COMMUNITY DEVELOPMENT DEPARTMENT  
80 Columbia Avenue ♦ Marysville, WA 98270  
(360) 363-8100 ♦ (360) 651-5099 FAX

Re: Marysville Corporate Center – *Technical Review 1*  
PA 22004

RE: Marysville Corporate Center, File# PA22-004  
Binding Site Plan  
15908 47<sup>th</sup> Ave., Multiple Parcels

1 GRADING PLAN - NW
 SCALE: 1" = 30'

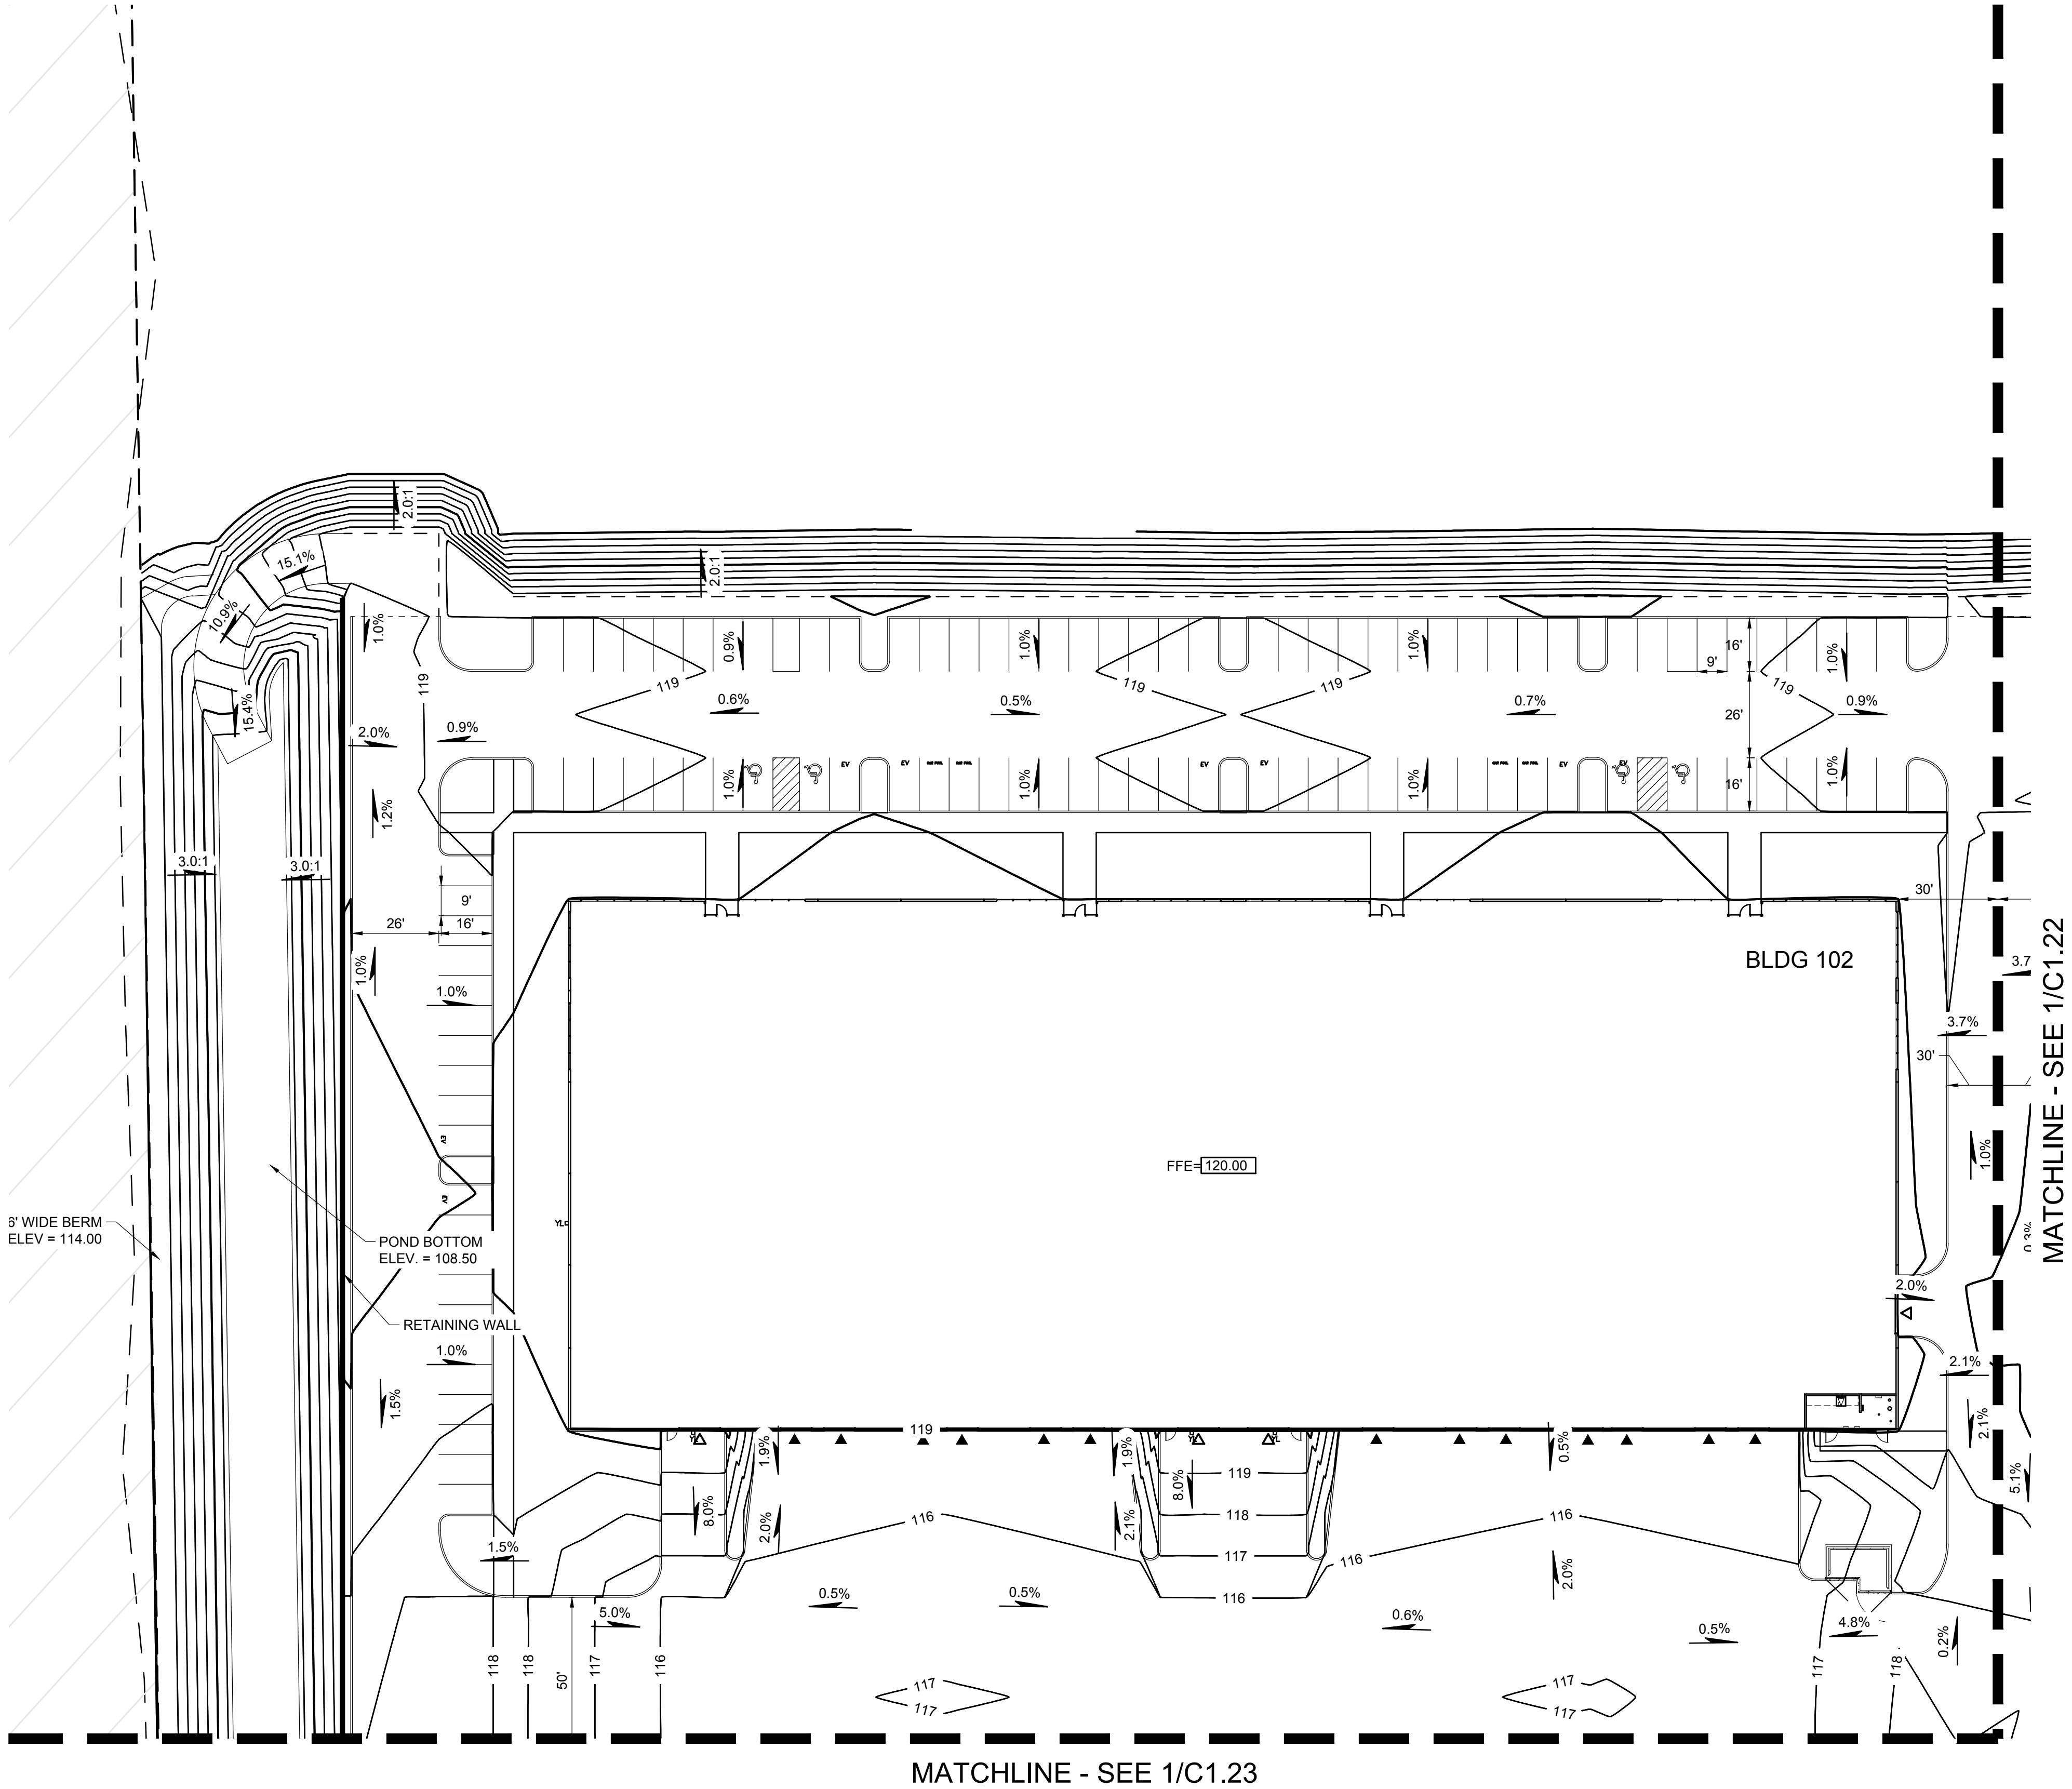
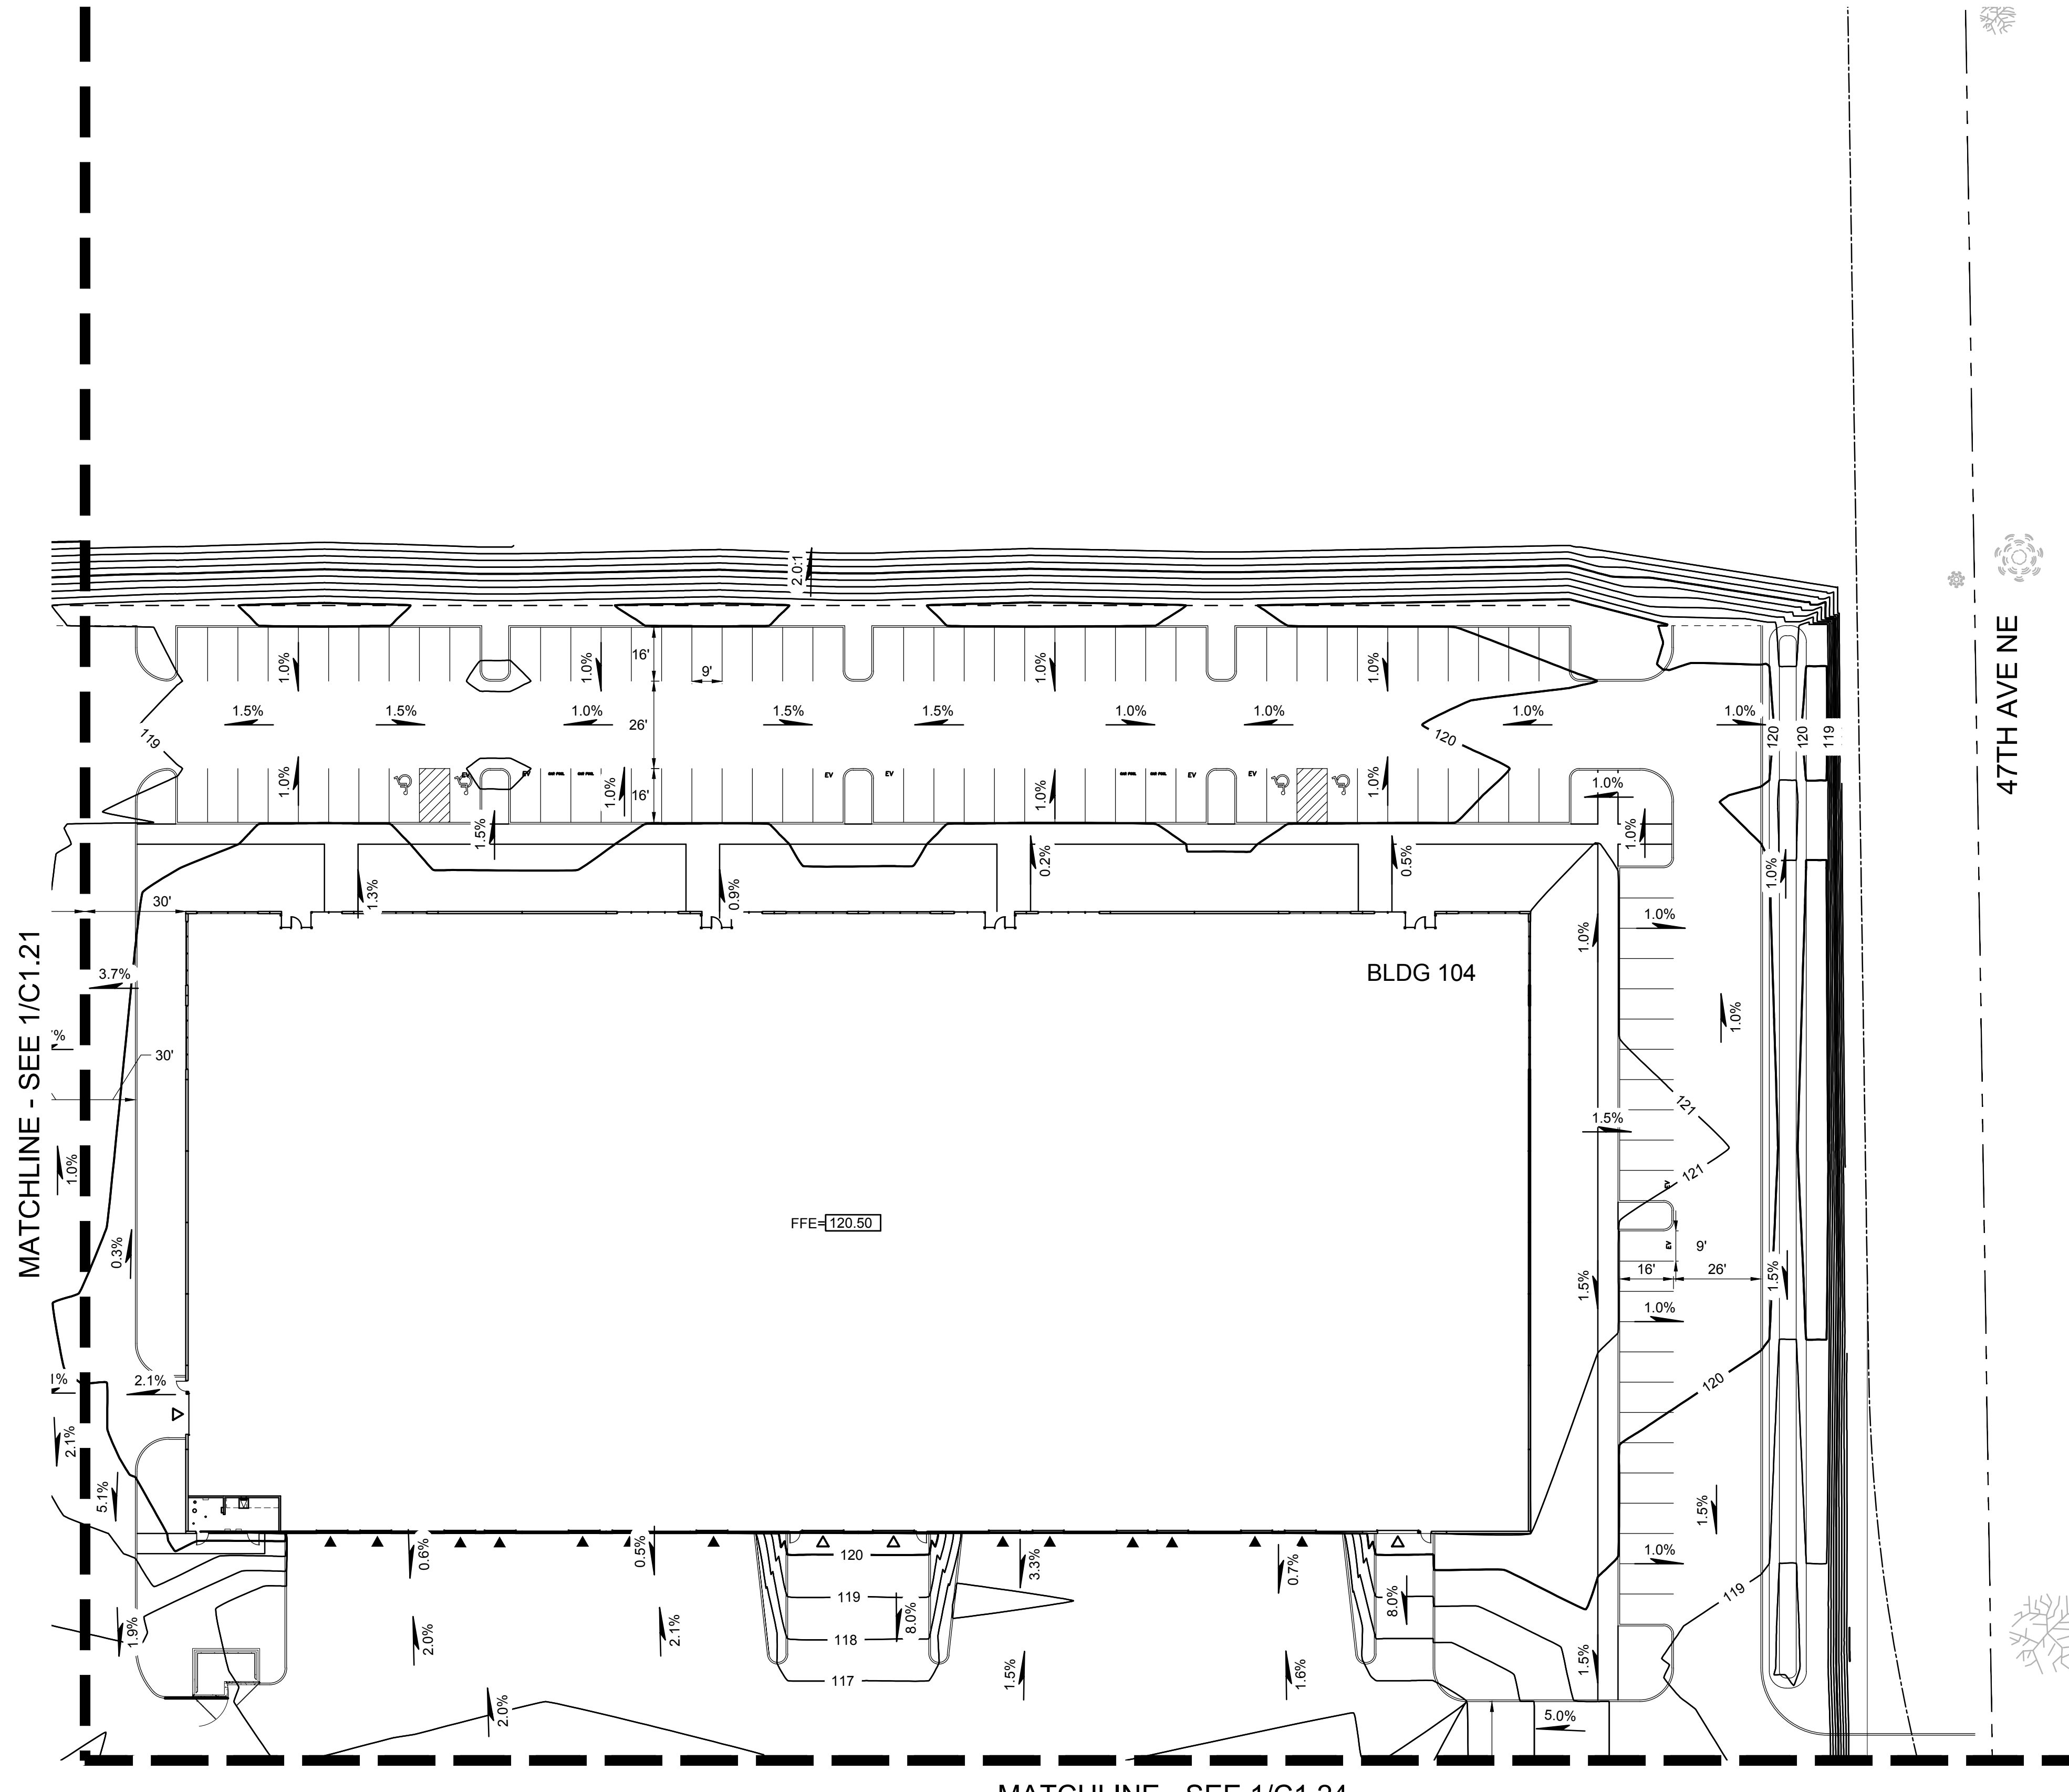
7. Survey control datum NAVD-88 and NAD-83 are required to be used. Civil construction plans will not be accepted in any other datum.
8. The onsite grading and placement of any retaining walls must be compliant with section 22D.050.030 of the MMC.
